Appendix 1 - Pre-application comments

26 May 2022

Case Number EQ/22/50230
Proposal Extensions and alterations
Site Southwood, Beechwood Lane, Burley, Ringwood, BH24 4AS

## Appendix 2 – Floorspace Calculations for Southwood, Beechwood Lane, Burley, BH24 4AS

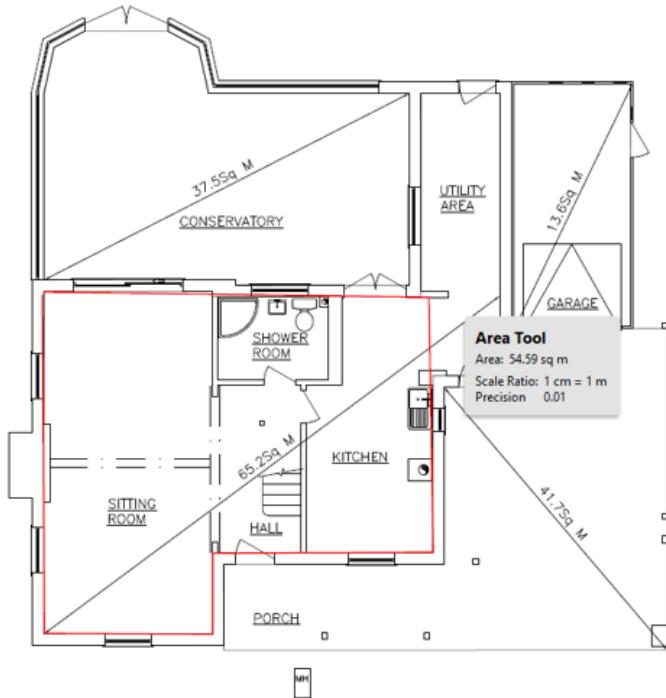
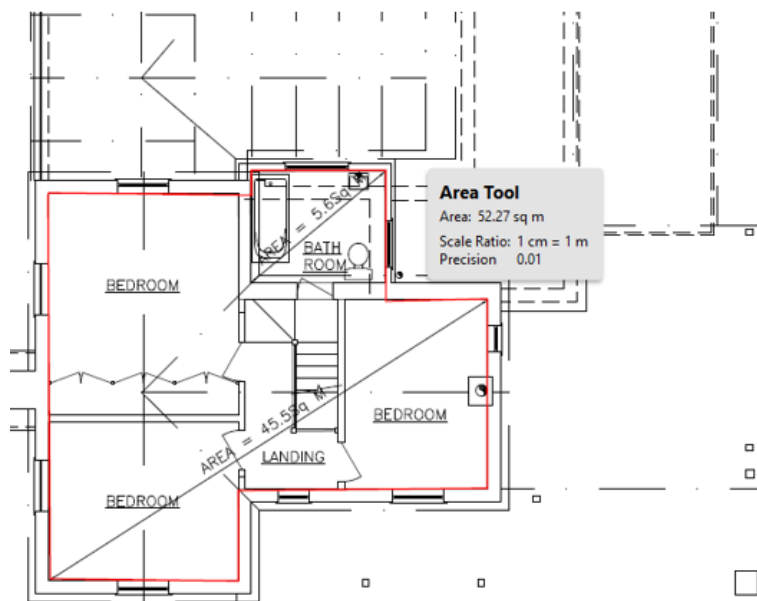
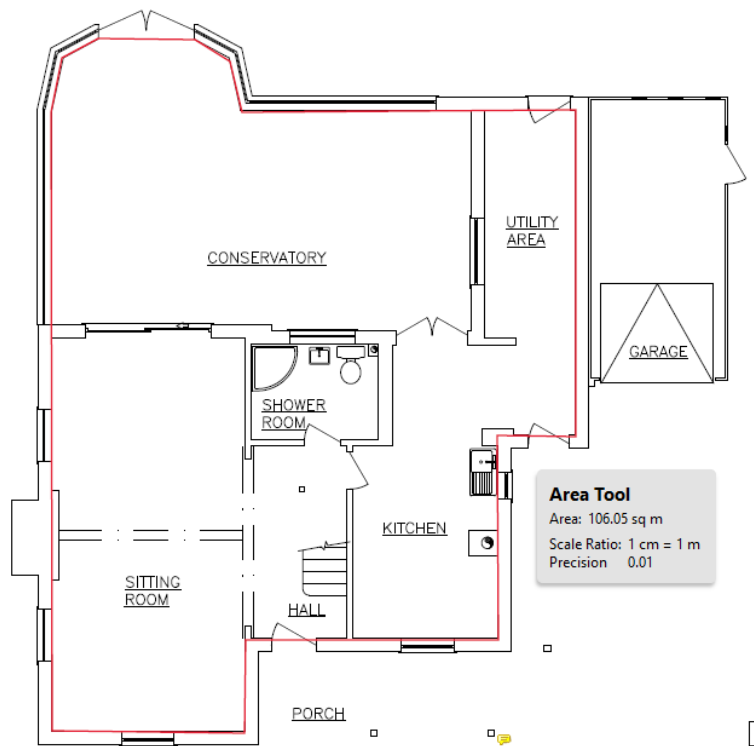
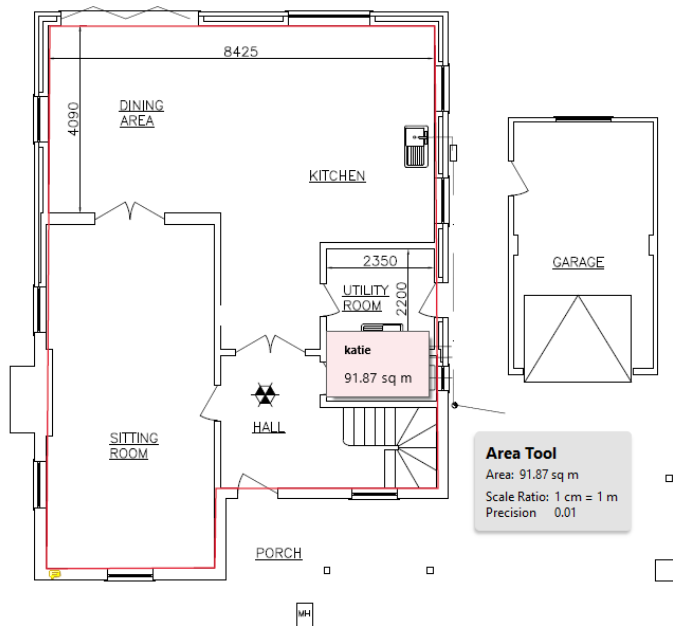
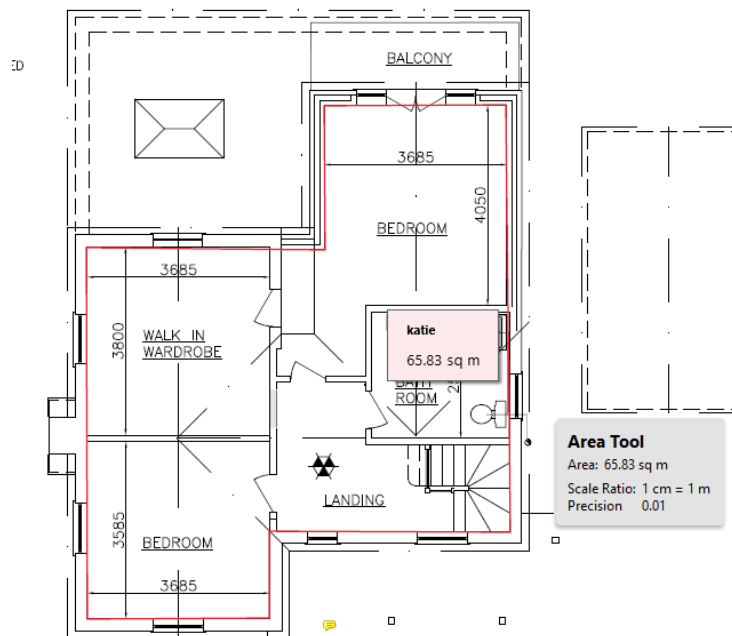
As you have described, the dwelling has already exceeded its floorspace limitation as set by Policy DP36 of the Local Plan. However, as there would be no net increase in floorspace (based on the plans provided), the principle of the proposal would be acceptable. It is noted that a significant area of glazing would be removed which is considered to result in numerous environmental benefits. However, extensions should be subservient in their scale to the existing dwelling, and notwithstanding the existing two storey element, effort needs to be made to ensure that the two storey extension proposed is not overly dominant; this does appear to be the case when looking at the rear elevation, exacerbated due to its width being wider than that of the existing two storey element.
